Our Ref: FP/118/20/NMA

Non material amendment following the grant of FP/192/19/HH for the addition of first floor dressing room obscured glazed window, only openable above 1.7m above finished floor level & alteration to family bathroom window to be obscured glazed & only openable above 1.7m above finished floor level.
Bright Side 5 Rudwicks Close Felpham PO22 7NG

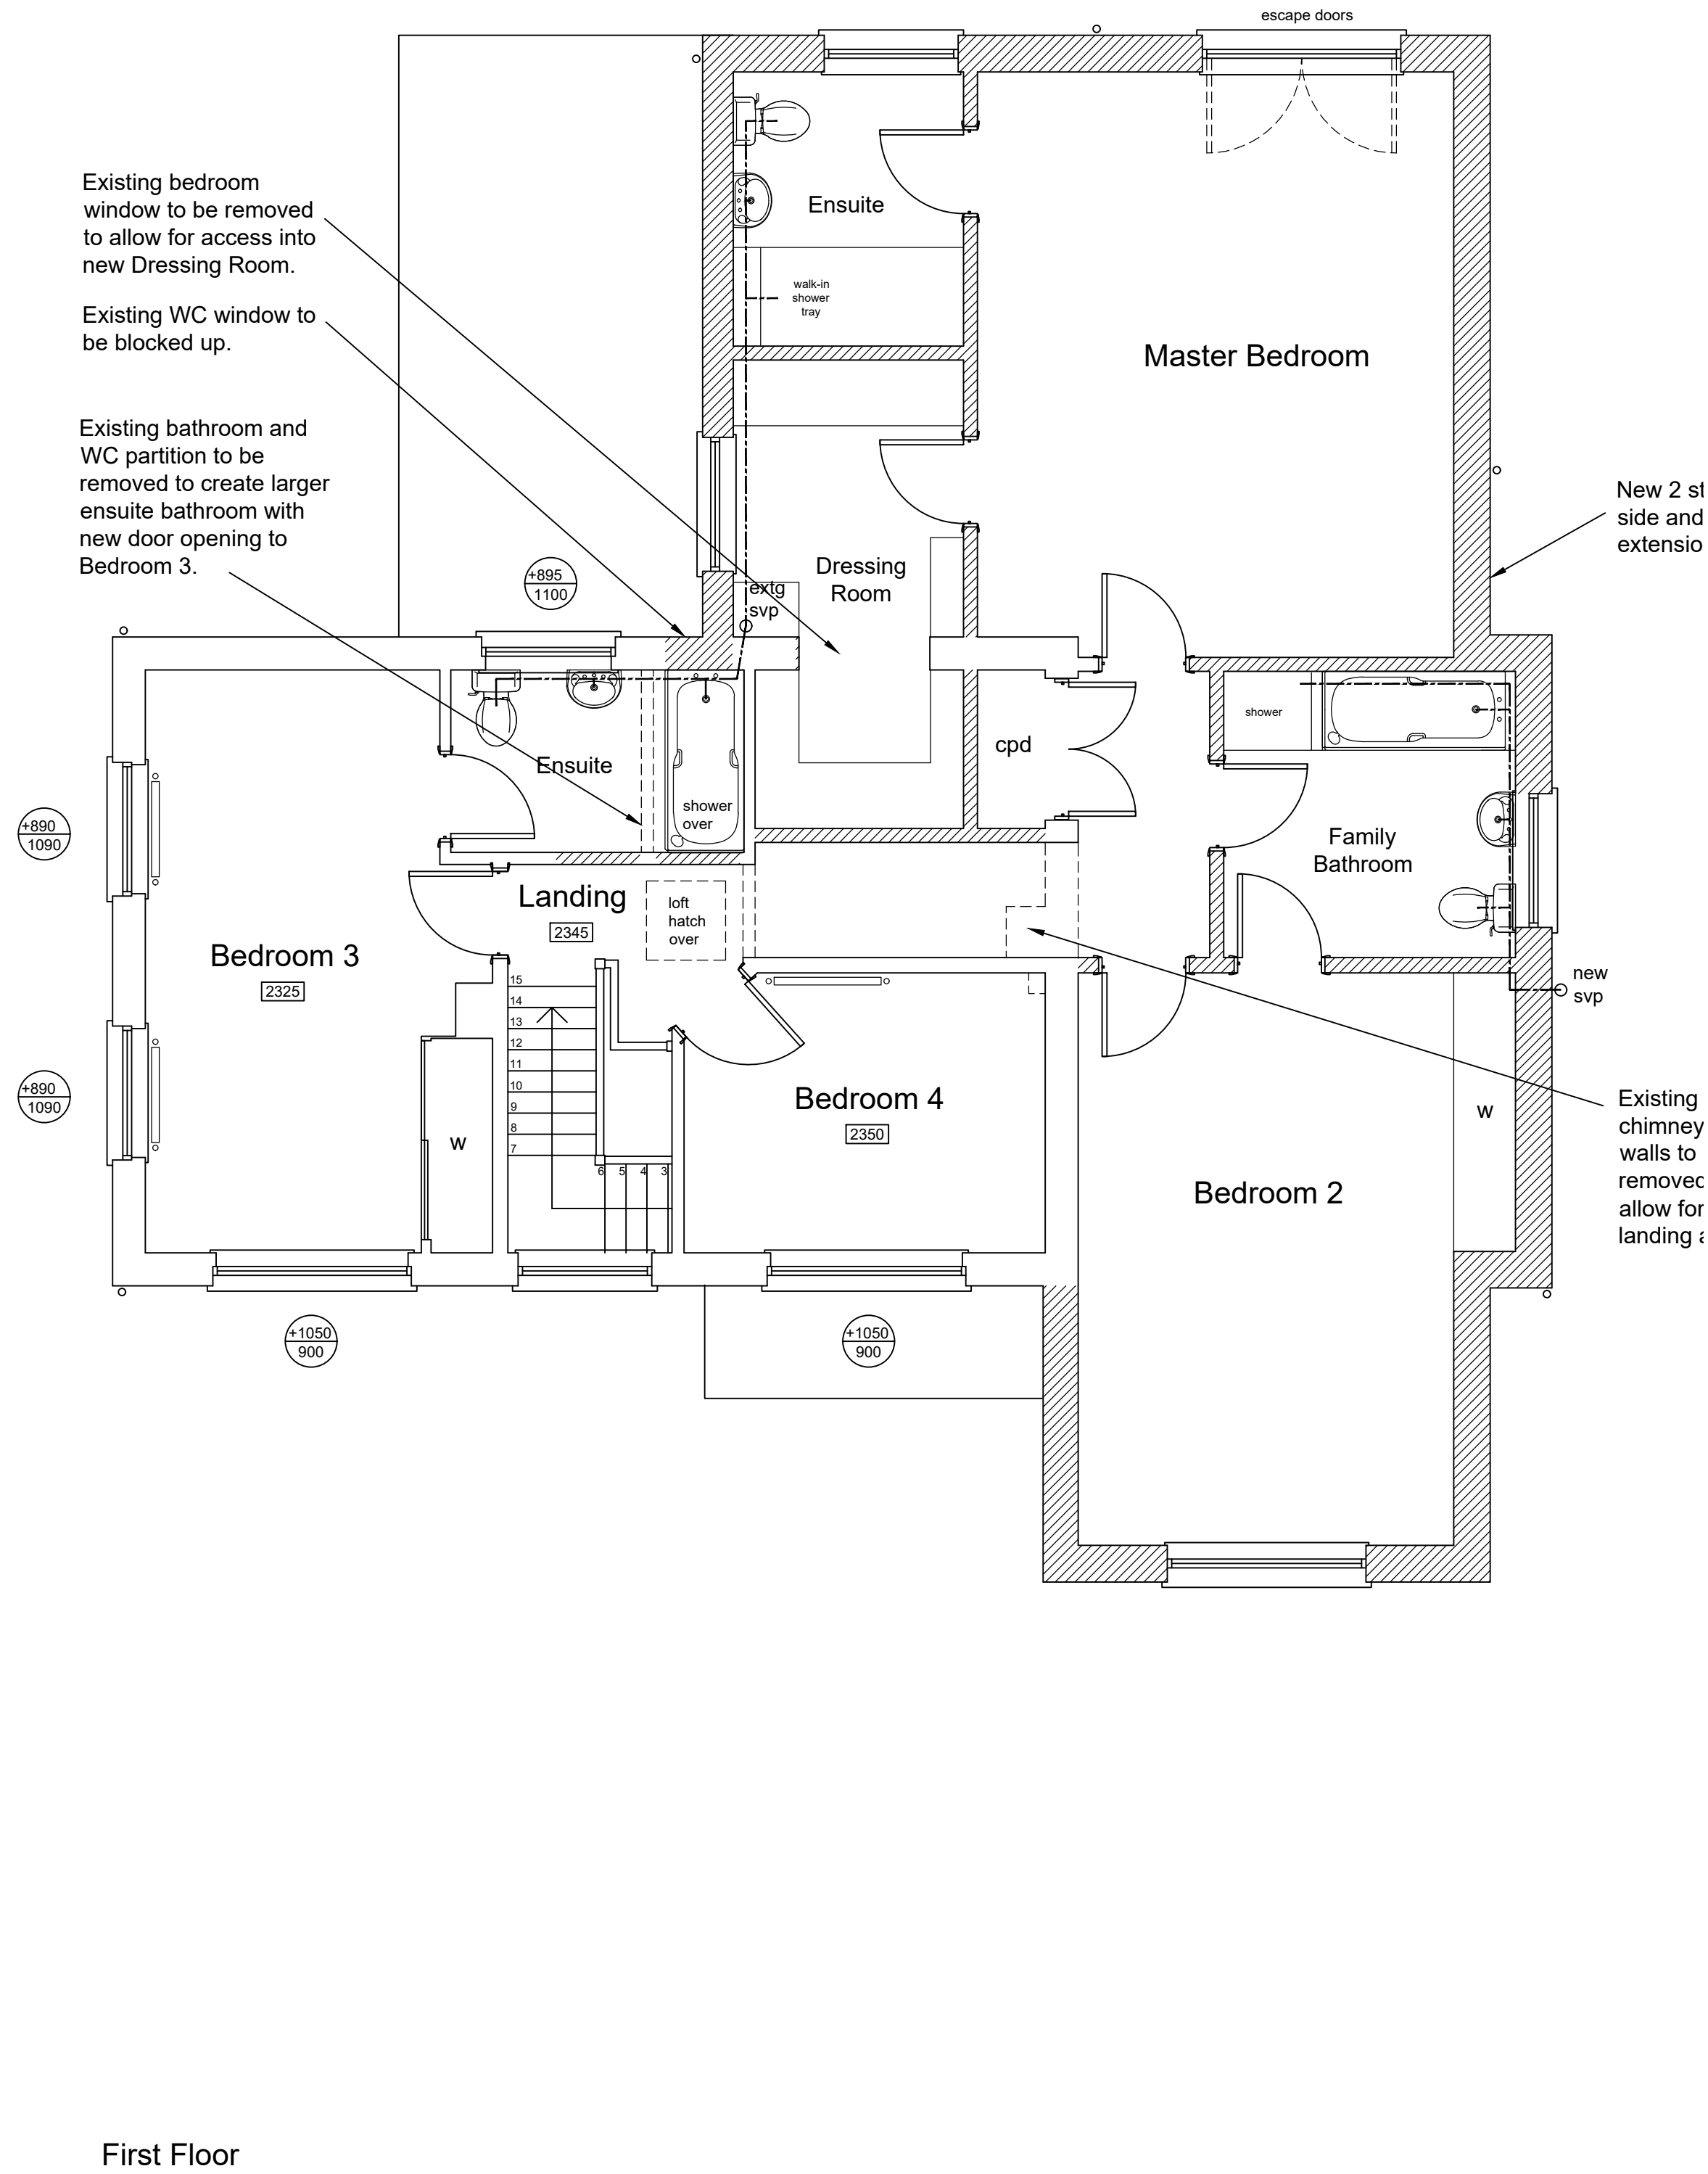
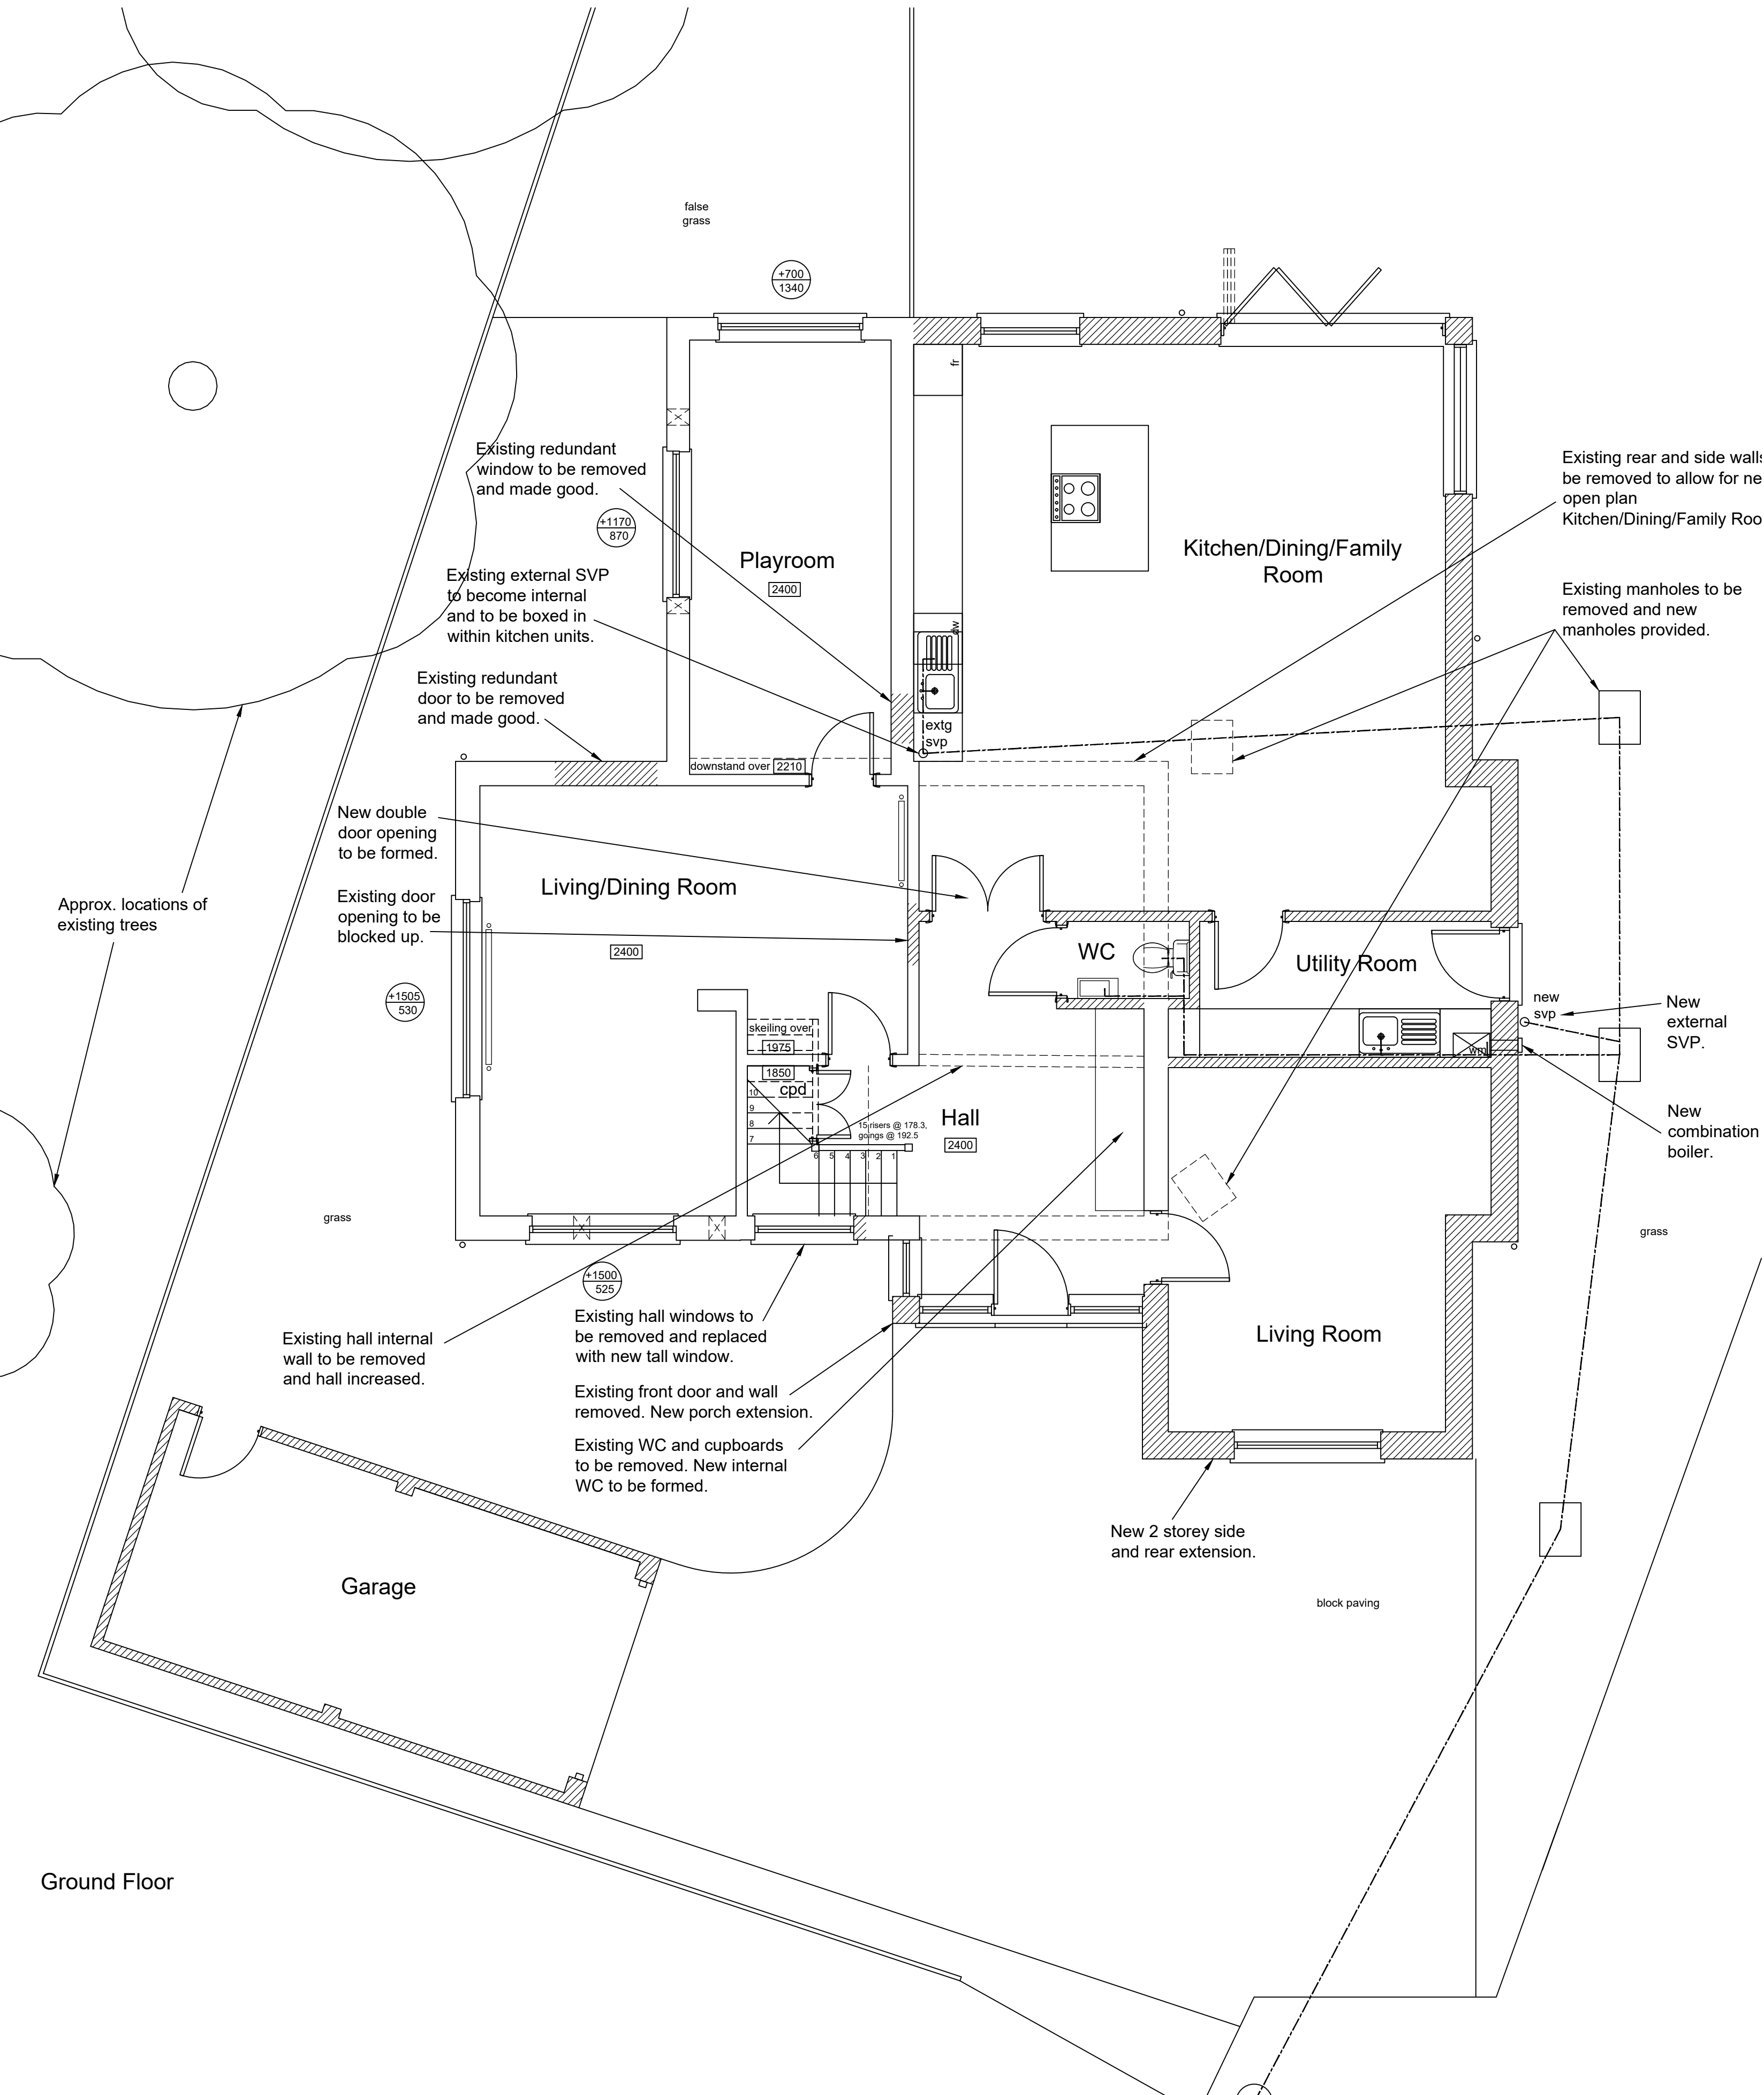
The reasons that these proposals have not been accepted as a Non-Material Amendment is because the dressing room window is likely to have the potential to overlook the rear gardens of the properties to the side, located in Limmard Way. Whilst it is proposed to be obscured glazed, the LPA would not being able to enforce this.

Alternatively, a window could be introduced to the side elevation after the build under permitted development which in order to comply with criteria would be required to be obscured glazed.
